From: Anita Gardner
Sent: 04 April 2019 10:45
To: Planning.Responses
Subject: FW: Land south of Cornfield Close, Littlehampton - LU/330/18/PL
Attachments: P0516 2000 01 Proposed Site Plan.pdf; P0516 2001 01 Proposed Block Plan.pdf

Can you let me have a revised site plan indicating the position of the on-site unequipped LAP to be provided and confirmation that the area will include a seat, bin and natural elements ie mounds, rounded boulders? It would be appreciated if this could be provided by the end of the week to allow time for it to be scanned and added to the application prior to DC Committee.

Status
Planning

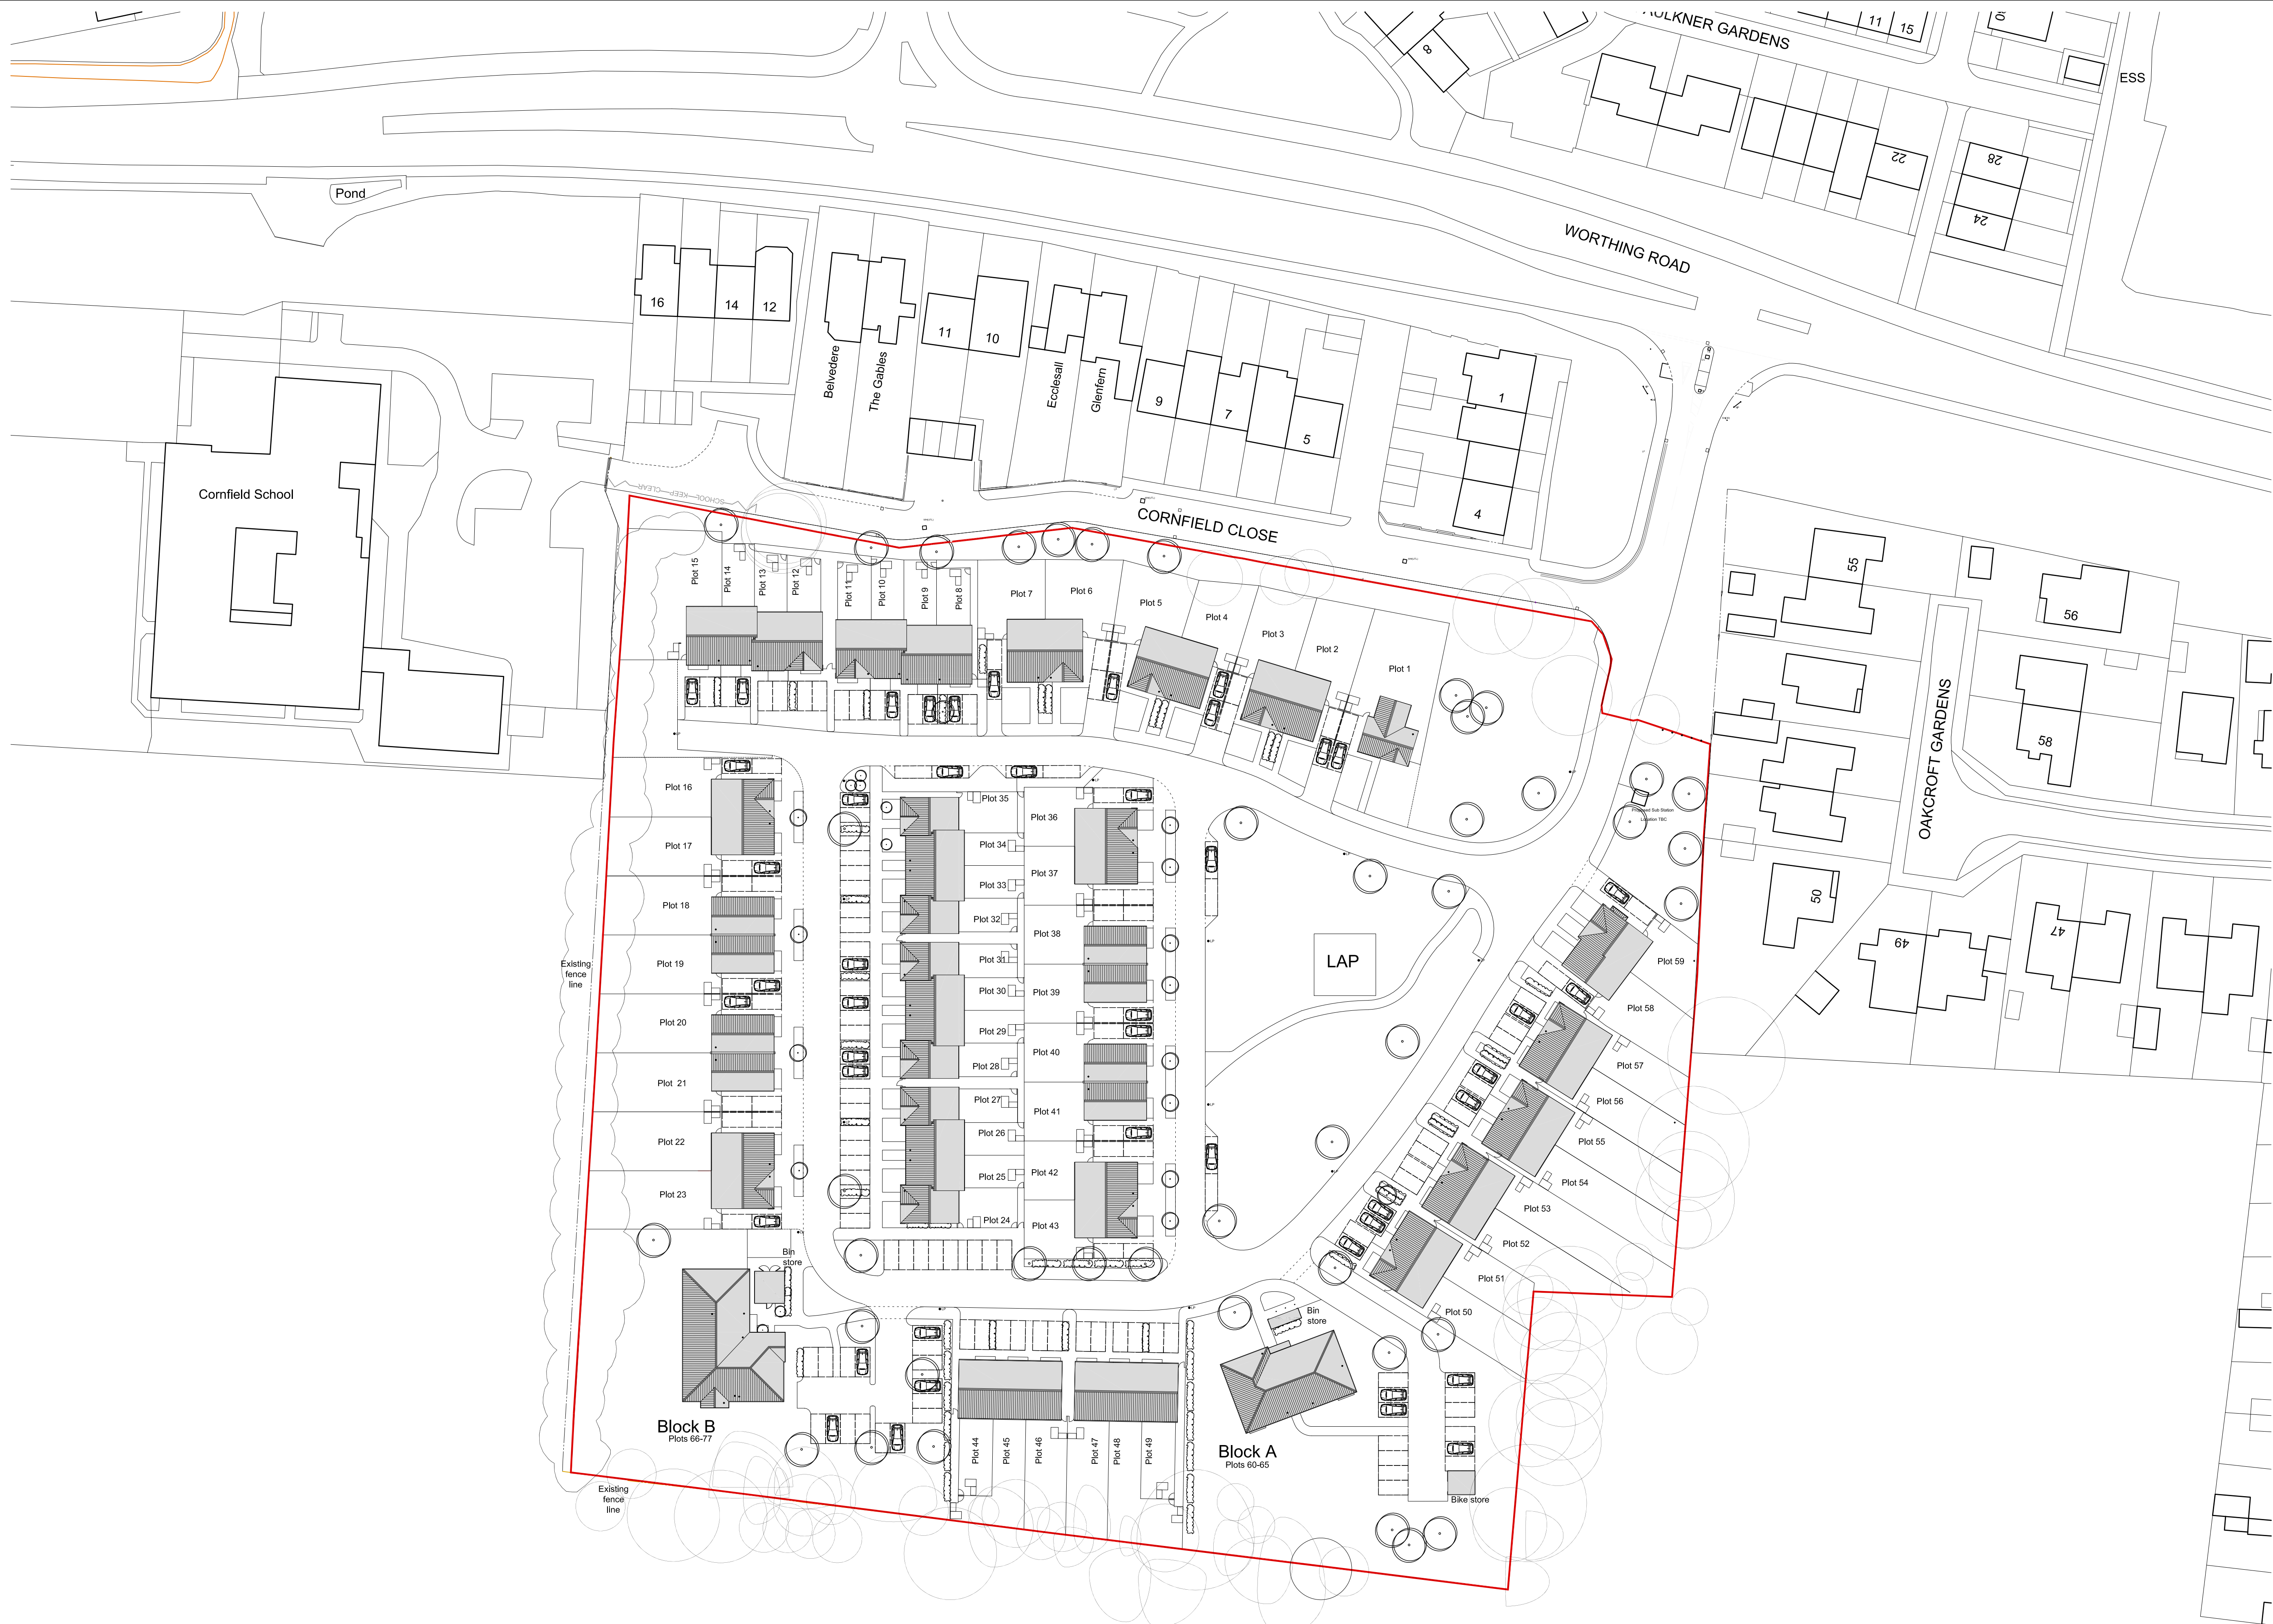
We would require that an on-site unequipped LAP is provided to contain a seat, bin and natural elements ie mounds, rounded boulders and to be shown on plan.

Please find attached a revised site plan as requested accommodating LAP location, the architect has also amended the block plan accordingly for consistency.
